X. Decision and Conditions of Approval

Kittitas County Community Development Services grants *preliminary approval* of the Egan Short Plat SP-23-00001 based on the above staff analysis, findings of fact, and conclusions with the following conditions of approval.

EGAN SHORT PLAT
PART OF SECTION 2, T. 19 N., R. 15 E., W.M.
KITTITAS COUNTY, WASHINGTON

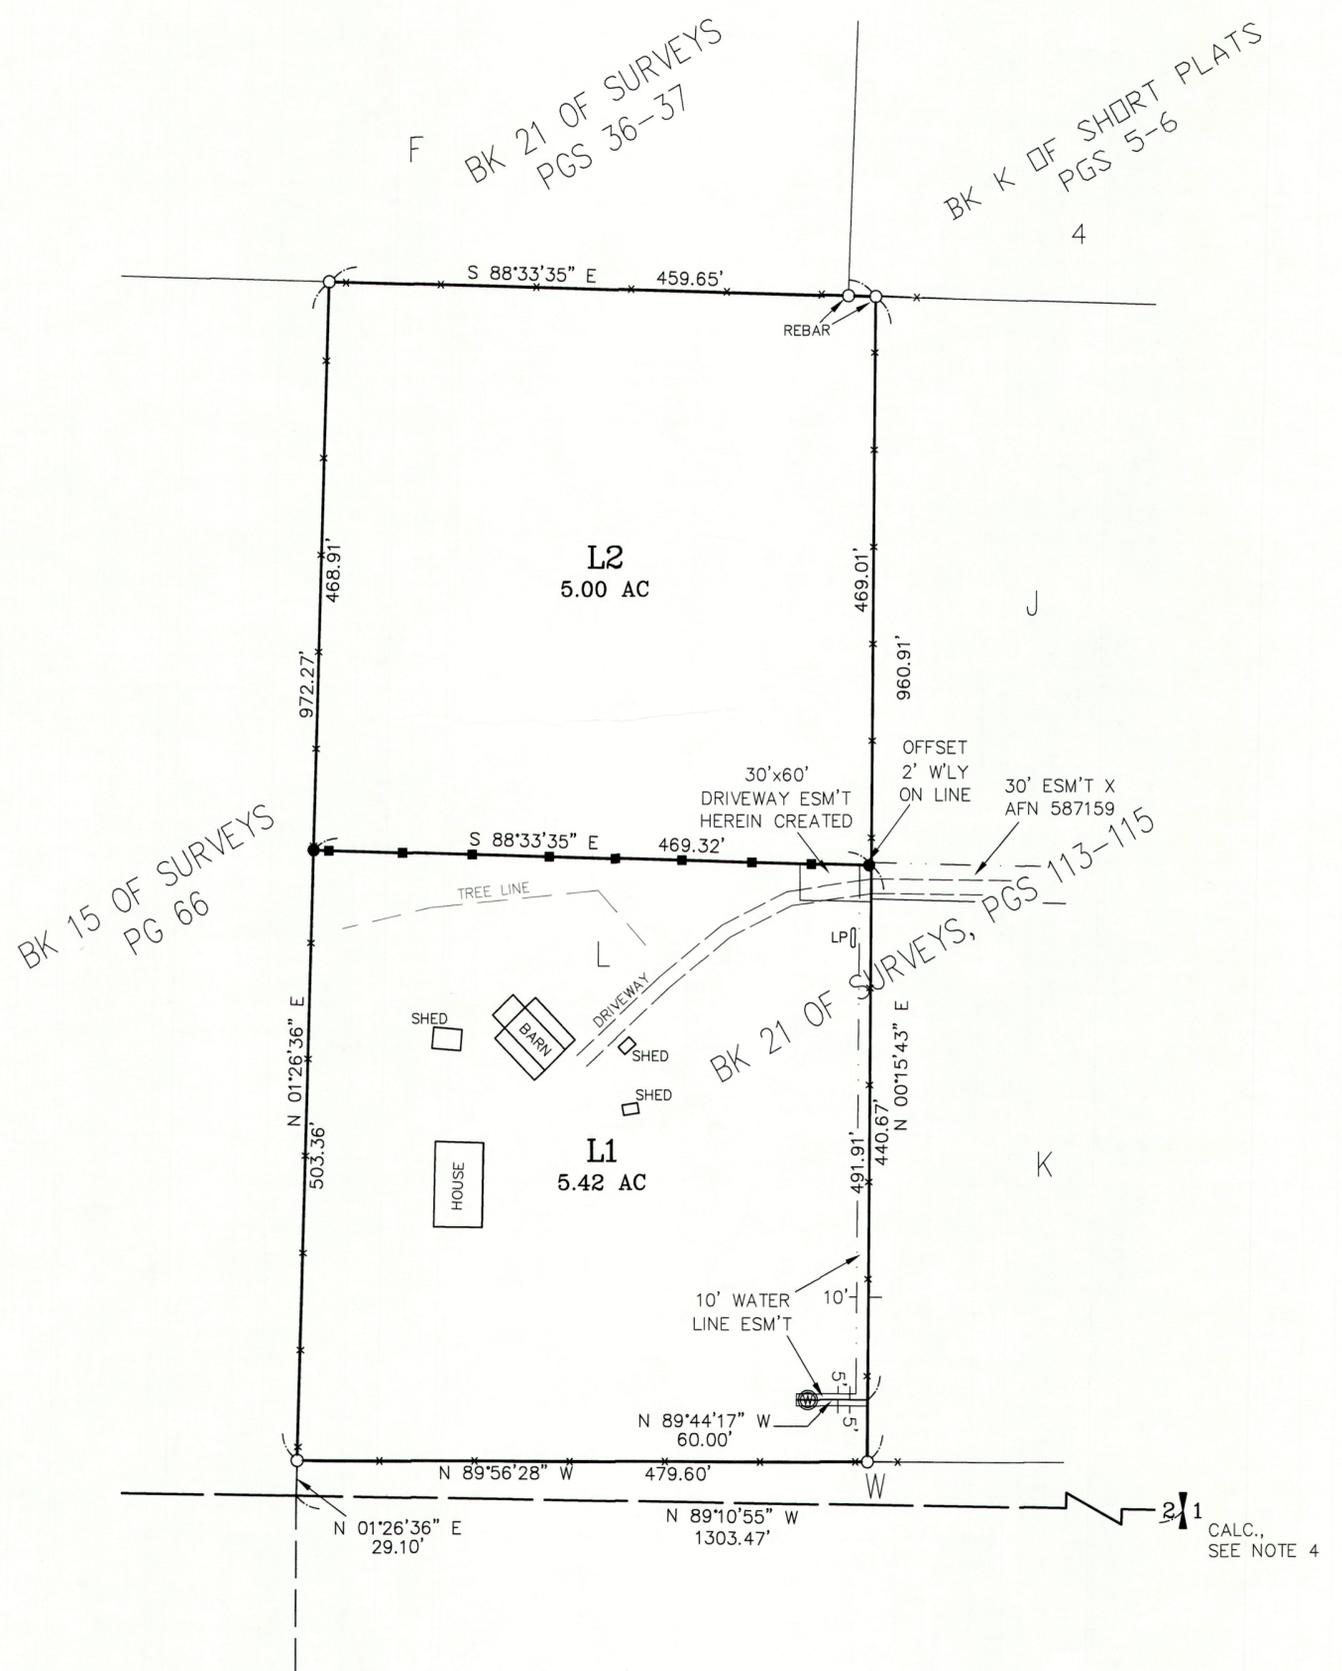
- A. Final plat shall meet the requirements of WAC 332-130-145 in regard to contour line sources, vertical datum, and contour accuracy. *No Contours*
 - B. The 30x60 driveway easement shall be labeled as existing, herein created, or created via separate document. *Updated See Sheet 1*
